Council Reference: D24/236980 Contact Person: Justin Lamerton

6 June 2024

Mundamia Mod 3 – SSD- 7169 Shoalhaven City Council Response to Request for Comments

I refer to the Department of Planning, Housing, and Infrastructure's request for comment in relation to Mundamia Mod 3 over property at Jonsson Rd, Mundamia (Lot 30 DP 1198692).

RATIO 1:20
TYPICAL CONCRETE
EDGE STRIP

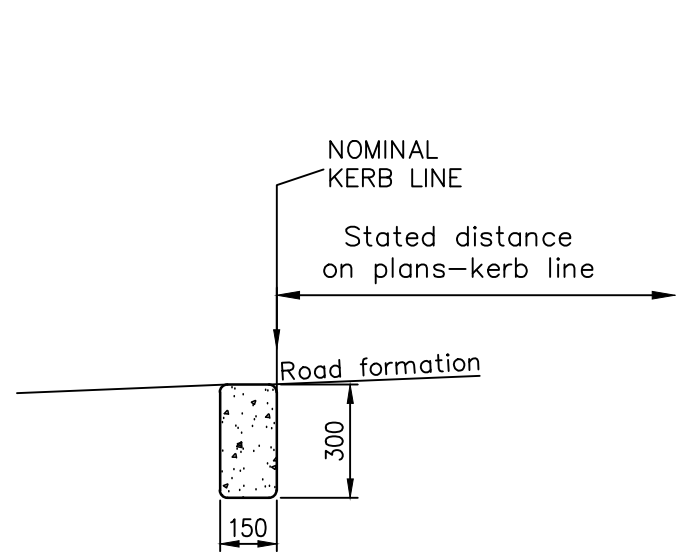
Applicant must demonstrate how they are delineating the boundaries of the APZ areas - such as a concrete edge beam. Council are not willing to accept bollards as a means of delineation due to ongoing maintenance concerns.
